Patrick and Alice Hayes
'Teach Tobar', Knockduff, Dunmanway, Co. Cork, P47 PX73

An Coimisiún Pleanála
64 Marlborough Street
Dublin 1, D01 V902
By email: appeals@pleanala.ie

17 September 2026

Re: ACP-324277-26 (SU04.324277) — substitute consent
ACP-324278-26 (FD04.324278) — section 37L
Murray Brothers Tarmacadam Ltd, Ardcahan, Dunmanway, Co. Cork
Section 131 submission: notices of 27 and 28 August 2026

Figure 1: Hydrological Features including the local catchment area of the adjacent 'Boundary Stream'.

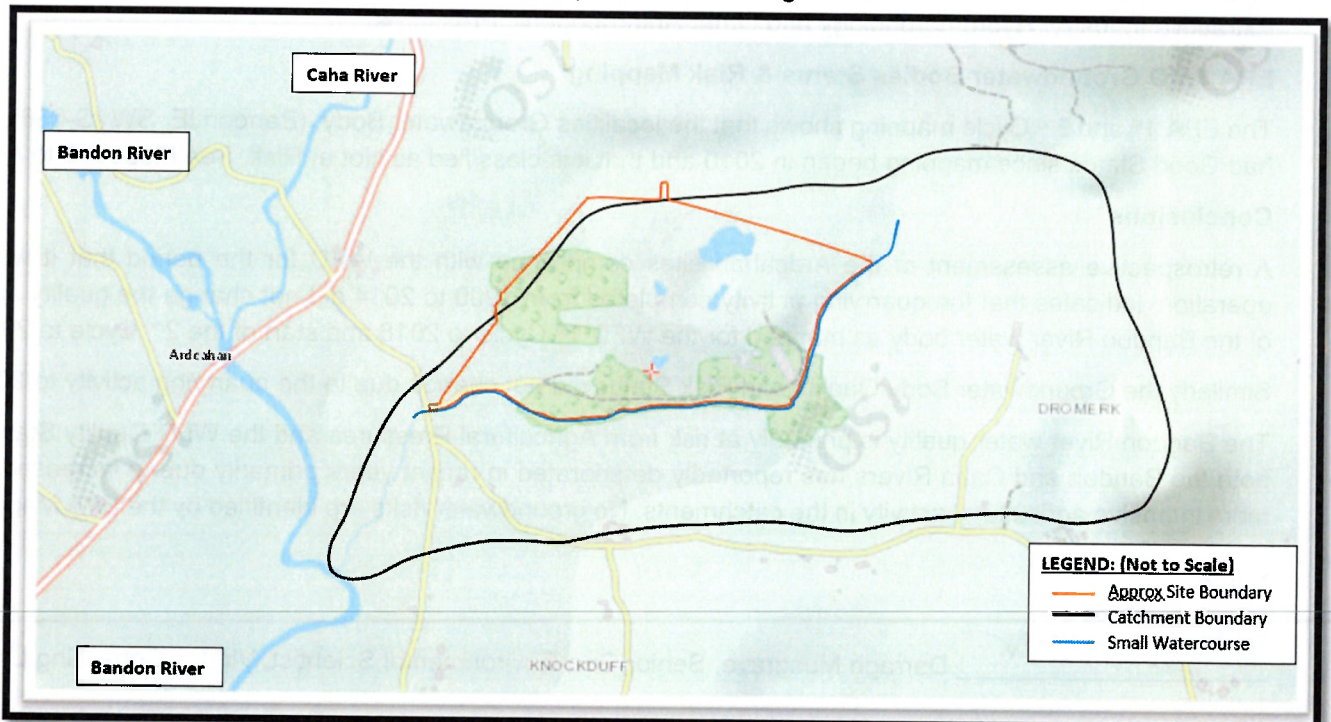
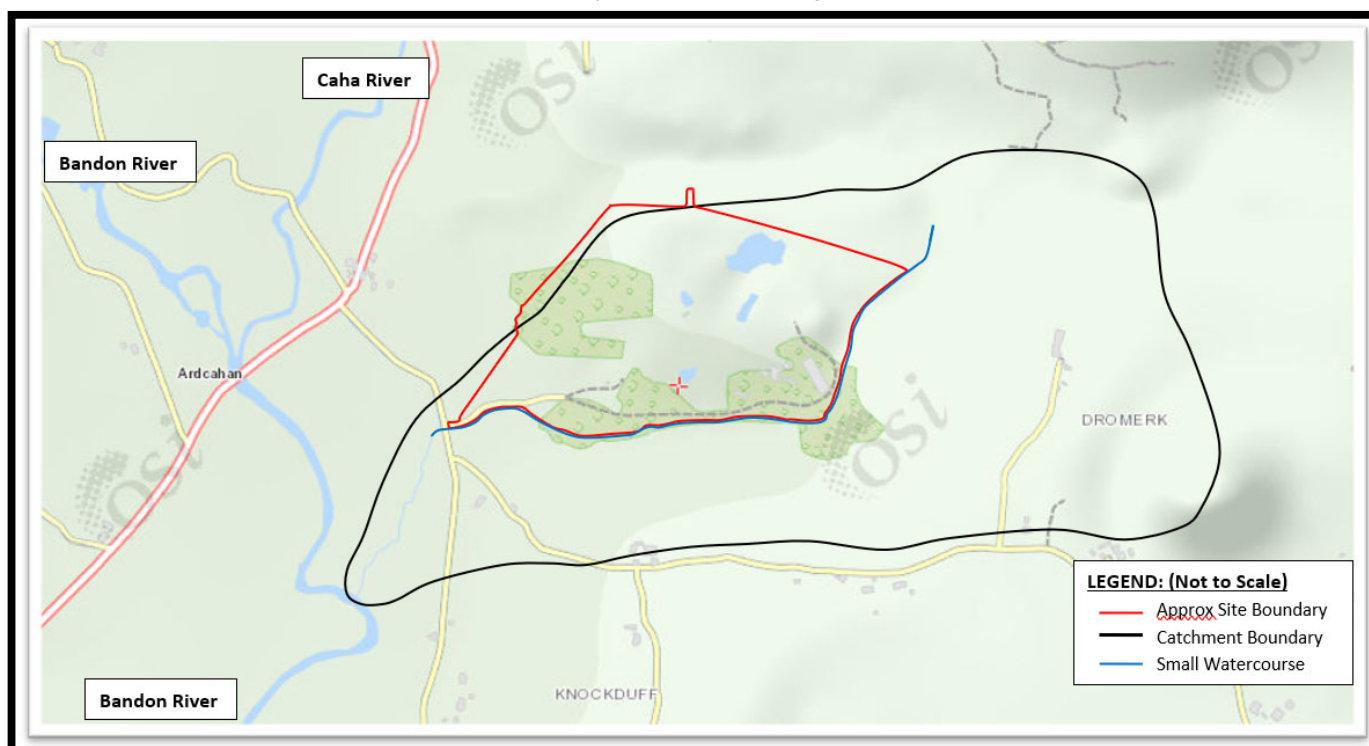
17. The Viridus letter also confirms how little of the substitute consent period the WFD data covers. It states that WFD Cycle 1 (2010 to 2015) and Cycle 2 are "the periods relevant", "as quarrying was undertaken prior to the WFD commencement up to 2014". That leaves roughly twenty of the twenty-four years in the application without any WFD classification. The EPA mapping on which Viridus relies classifies the Bandon_020 and Caha_020 river segments. The boundary stream that receives the site's discharges, and that Viridus identifies as the main hydrological feature, is not shown as a classified waterbody on those maps.

18. An Taisce asked (its section 2) for a WFD assessment "covering both the current status of the waters in the area of the site and the substitute consent period". The Viridus letter reports mapped status from 2010 onward. It does not cover 1990 to 2009, does not assess the boundary stream, and so does not provide the assessment An Taisce sought.

ARDCAHAN QUARRY COMBINED SUBSTITUTE CONSENT REMEDIATION AND S37L REGENERATION PLAN

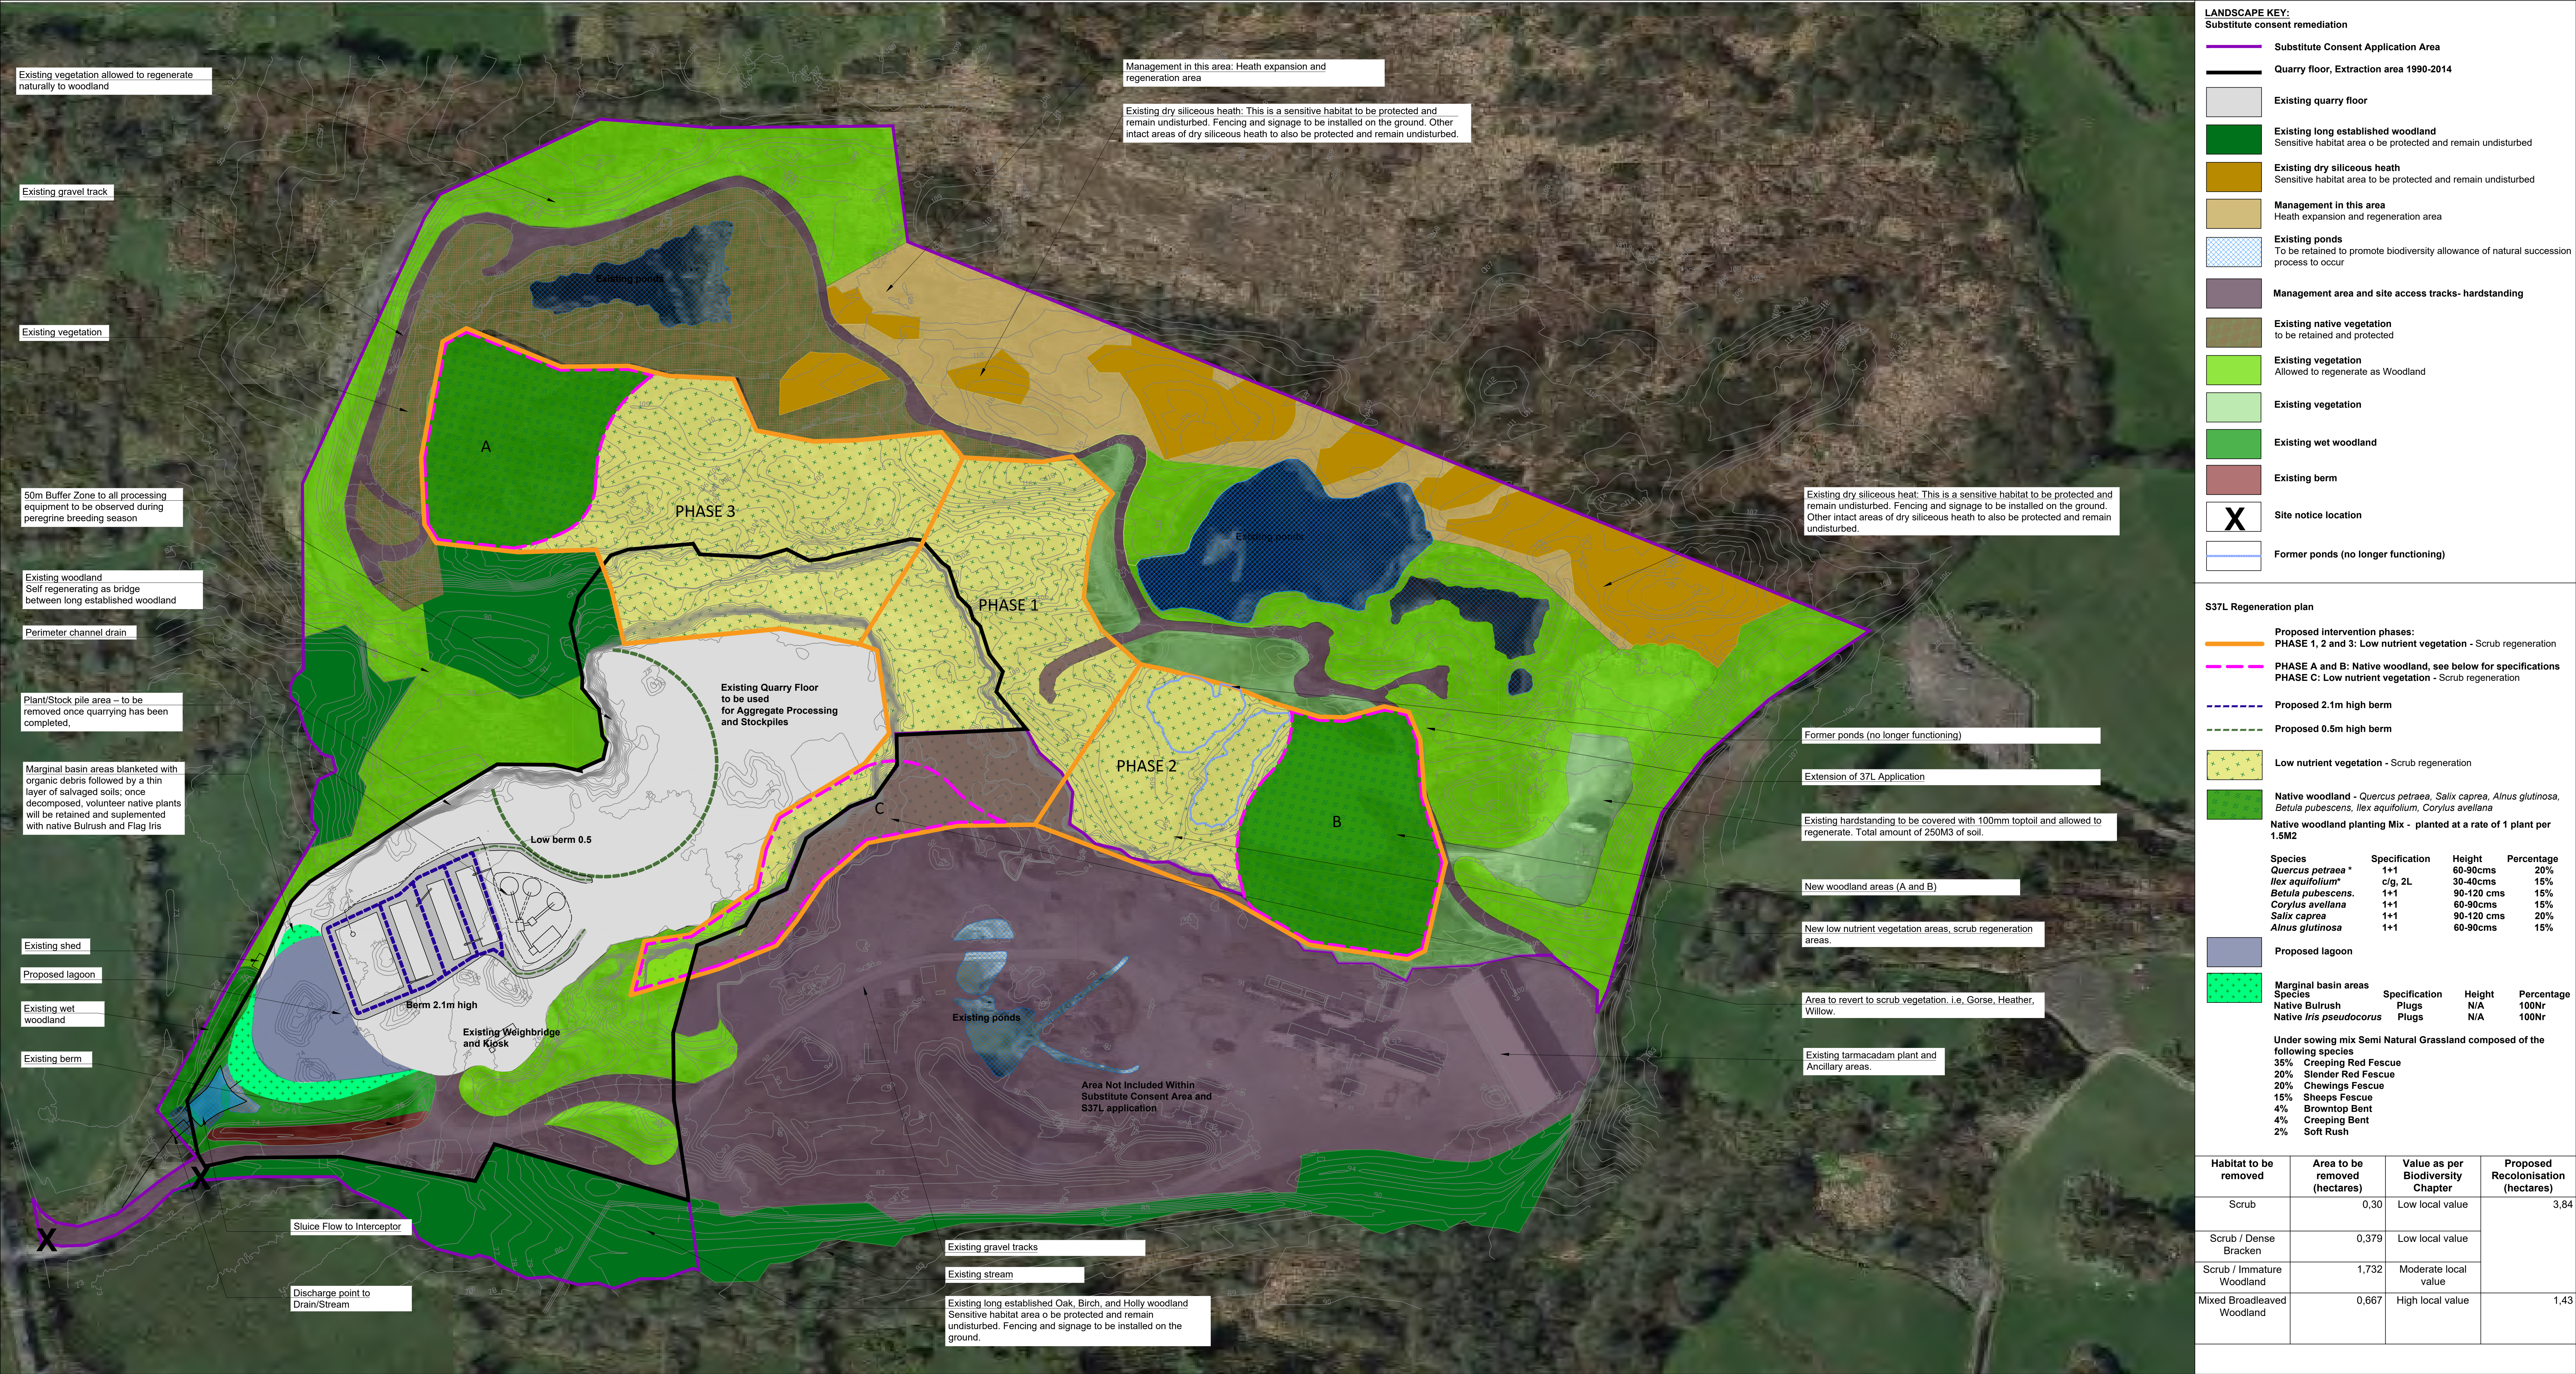
- 23. The applicant says the substitute consent application "must be assessed on its merits" and separately from the section 37L application (page 2). Yet it has prepared a new

composite drawing for this response (Appendix C) to show how the remediation plan and the section 37L regeneration plan "work alongside each other". The habitat table on that drawing lists 0.667 ha of mixed broadleaved woodland of "High local value", with 1.732 ha of scrub / immature woodland of "Moderate local value", for removal. Remediation of the historical loss of Annex I habitat cannot depend on a future development that removes further woodland. This supports An Taisce's position (its section 5) that remediation of historic impacts must take priority over future development.

Appendix A.4 – EPA Hydrology WFD Waterbodies Risk Mapping for the WFD 2nd Cycle Period.
WFD Bandon_020 River Showing Not At Risk (Green) and WFD Caha_020 River Showing At Risk (Red).
(EPA WFD Risk 2nd Cycle Mapping from <https://gis.epa.ie/EPAMaps/Water>.)

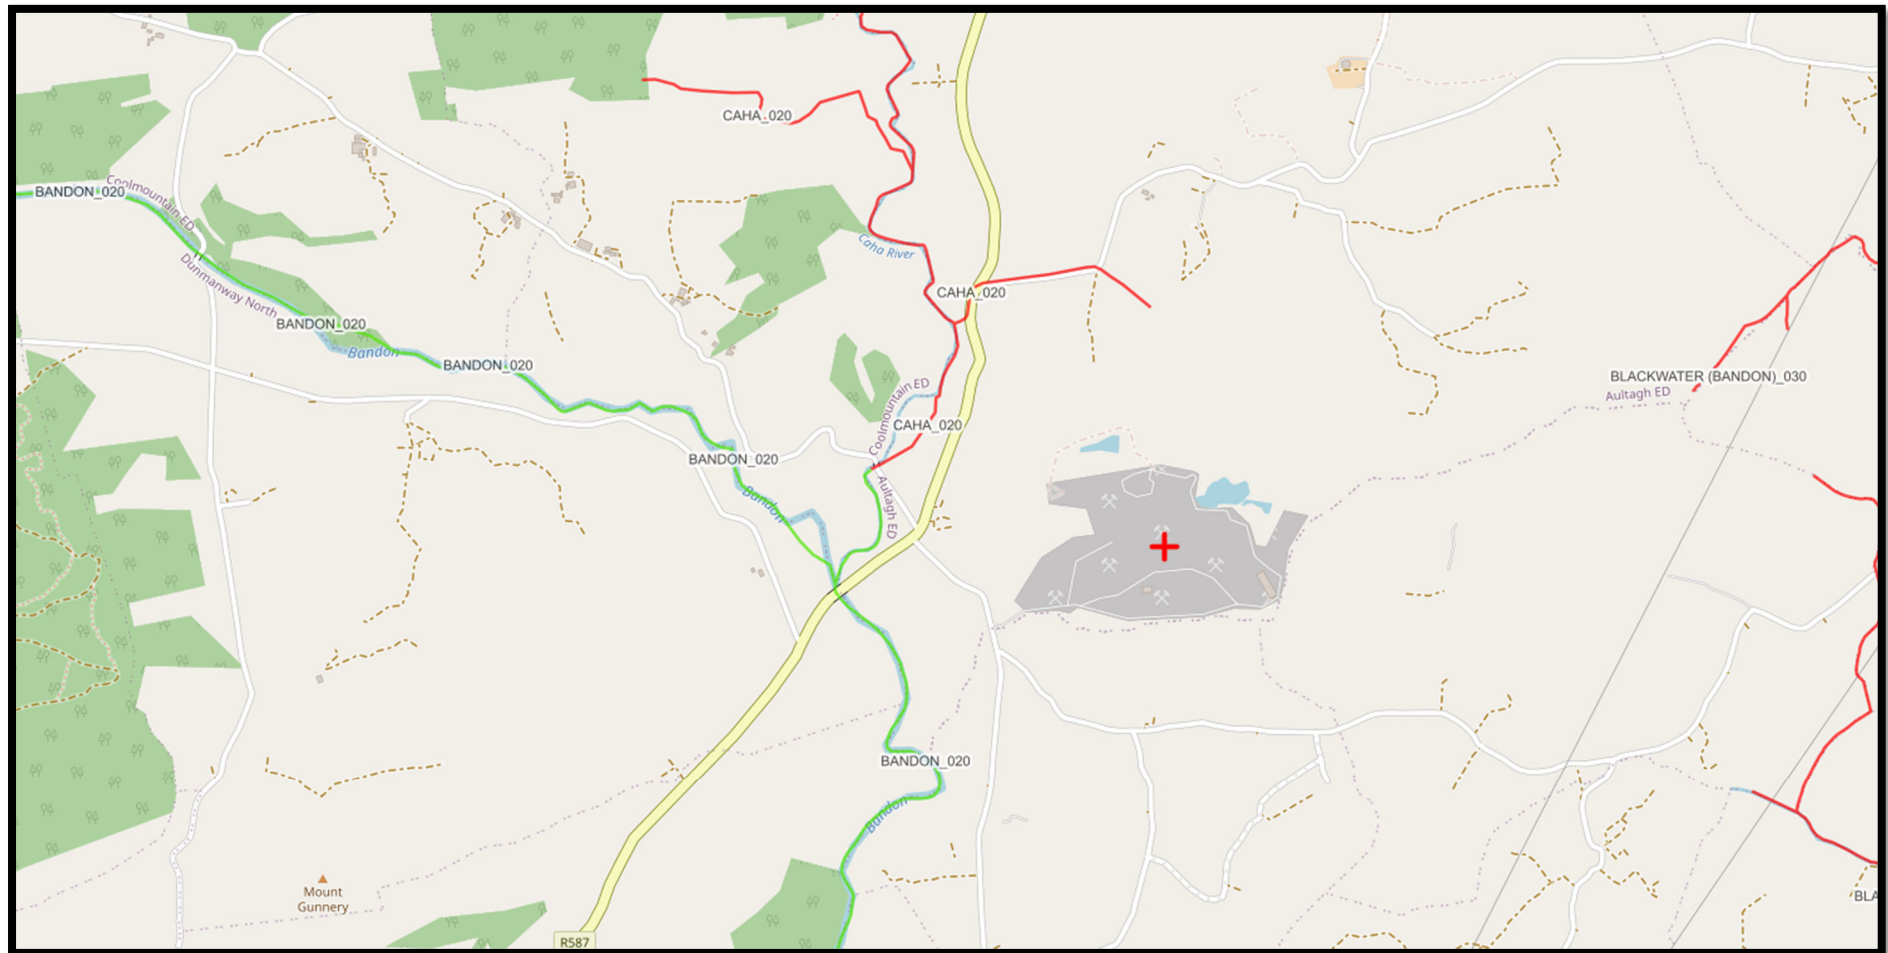
19. The applicant's letter and its own appendix also differ on the EPA data:
 - (a) The letter (page 4) states that the Bandon River "is deemed to be At Risk, primarily from Agricultural Pressures". Viridus states that the WFD 2nd Cycle risk mapping shows "the Bandon River is not at Risk but the Caha is" (Map A.4).
